**Our Case Number:** ABP-316025-23

**Re:** Wind energy development including 19 turbines and all associated works.  
Townlands of Clogherachullion, Cloghercor, Derryloaghan, Aghayeevoge, Cashelreagh Glebe,  
Darney, Drumard, and Drumnacross Co. Donegal

Attn: An Bord Pleanála  
RE: **OBSERVATION:** Case Reference: PA05E.316025  
Cloghercor Wind Farm – (SID Application)

Figure 10-1: Shadow Flicker Assessment Area

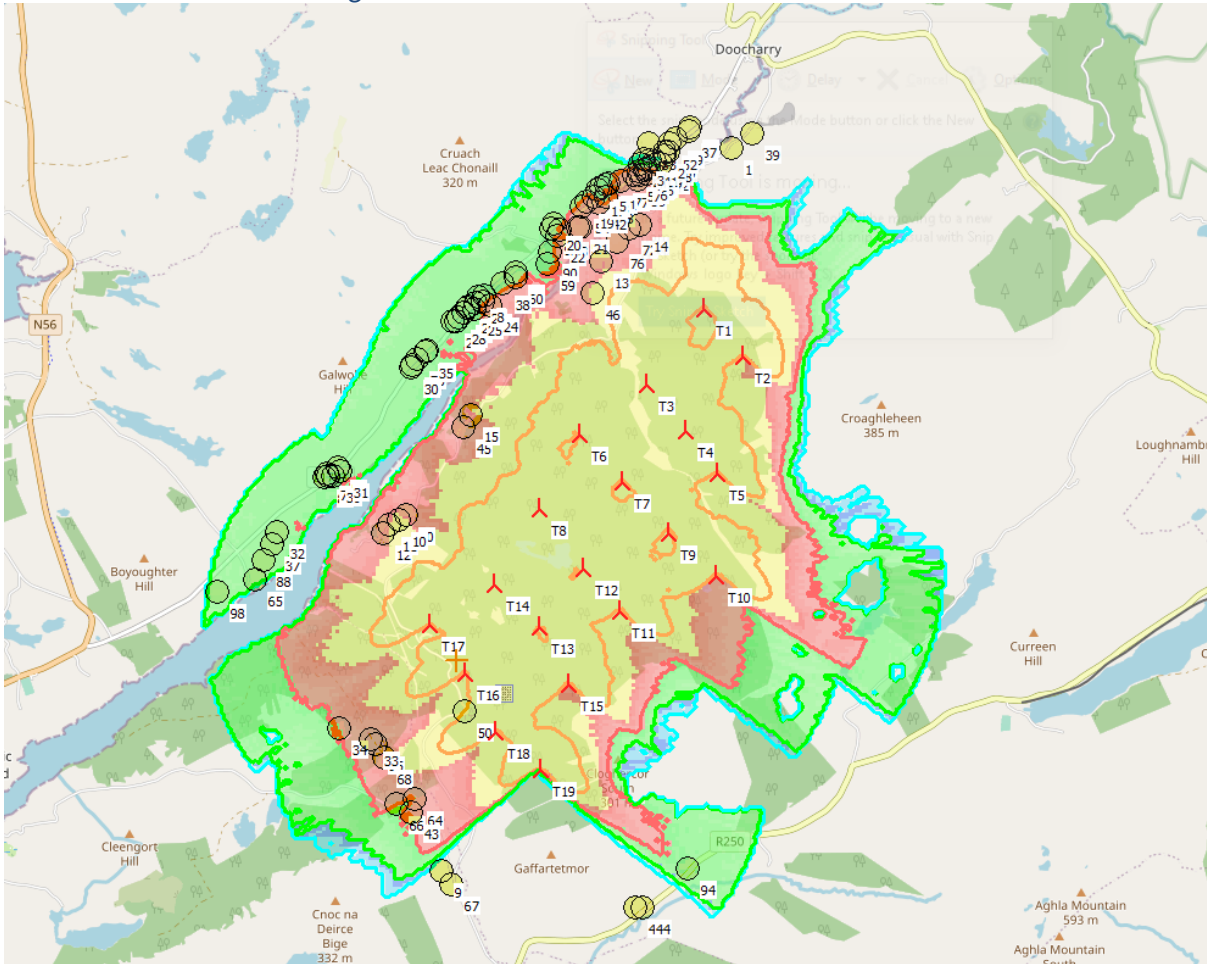
The shadow flicker analysis identified approximately 100 sensitive dwelling properties that would be affected. (This does not include any proposed developments.) It should be noted that the key plan (Figure 10-1: Shadow Flicker Assessment Area) which identifies these properties is presented in an illegible scale and the individual tags are not discernible.
